From: system@acelo.com on behalf of [John Rollason](#)
To: [Ashley Cheong](#)
Subject: Submission Details for John Rollason (object)
Date: Monday, 7 November 2016 11:44:14 AM

Submission for Job: #7056 Campbell's Stores The Rocks

Site: #3103 Campbell's Stores

**Figure 5** | The approved (left) and proposed (right) Bay 11 roof layout (Source: JPW Architects).

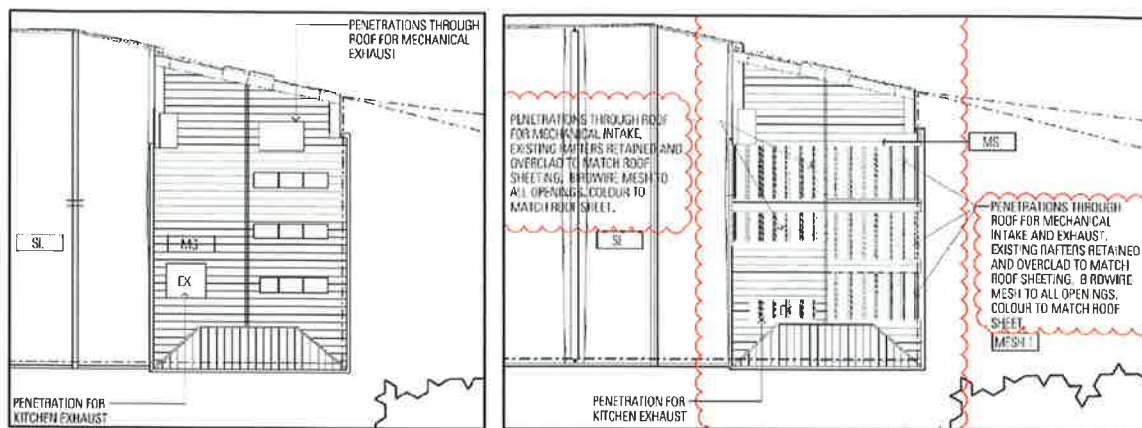
I refer to your letter of 25 October and the amended RtS Report on the Departments website. The response from Tallawoladah makes no reference to the objections previously made to the location of the mechanical Exhaust from the roof of Bay 11.

Nowhere have I been able to locate in the responses any information as to the precise level of noise expected to come from Bay 11 in respect of exhaust plant or any other mechanical or electronic plant or equipment to be located in Bay 11. Equally, there has been no specification of volumes of exhaust designed to emit from the roof of Bay 11 other than to conclude that it will be the combined total exhaust from the 13 proposed restaurants.

As previously submitted without response, the chosen exhaust site is adjacent to the only residential structure in Hickson Road between George Street North and The Sydney Harbour Bridge. It is now the time during design phase to either redirect the ducting to an outlet in, say, Bay 1 or 2 or to find an alternative engineering solution to the odour and noise problem which will necessarily arise from the current design proposal.
